Mark E. Jones, PE
Structural Engineering and Design

Ref: Site Observations and Analysis
471 Wade Stewart Circle
Lillington, NC
Permit No. SFD2409-0087
Project No: 24-214

ROOF TRUSS EGR SUPPORT DETAILS

Christie Yarbrough Enterprises LLC  
 1 Stafford Land-Roof-Blakely C BNS GRH  
**ROOF PLACEMENT PLAN**

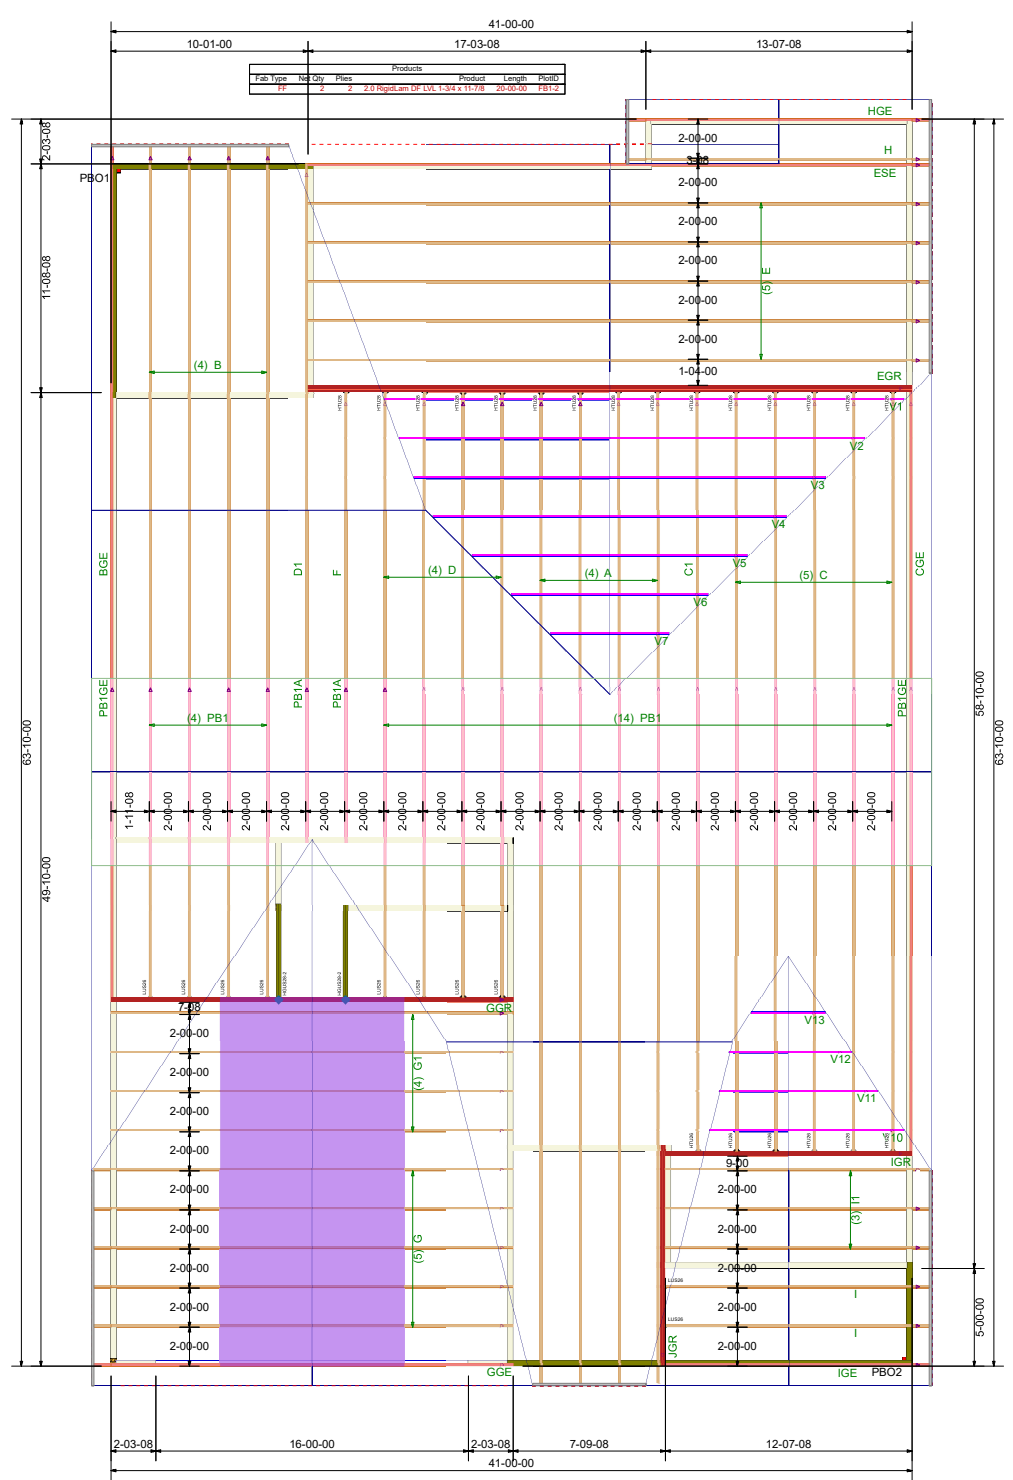
1. Provide engineering on EGR truss point loads with no enlarged footing.

1. The builder shall modify the wall framing at each end of the installed EGR truss as shown on the attached drawing. These modifications will result in distribution of the point loads at each end to be adequately supported by the existing footings.
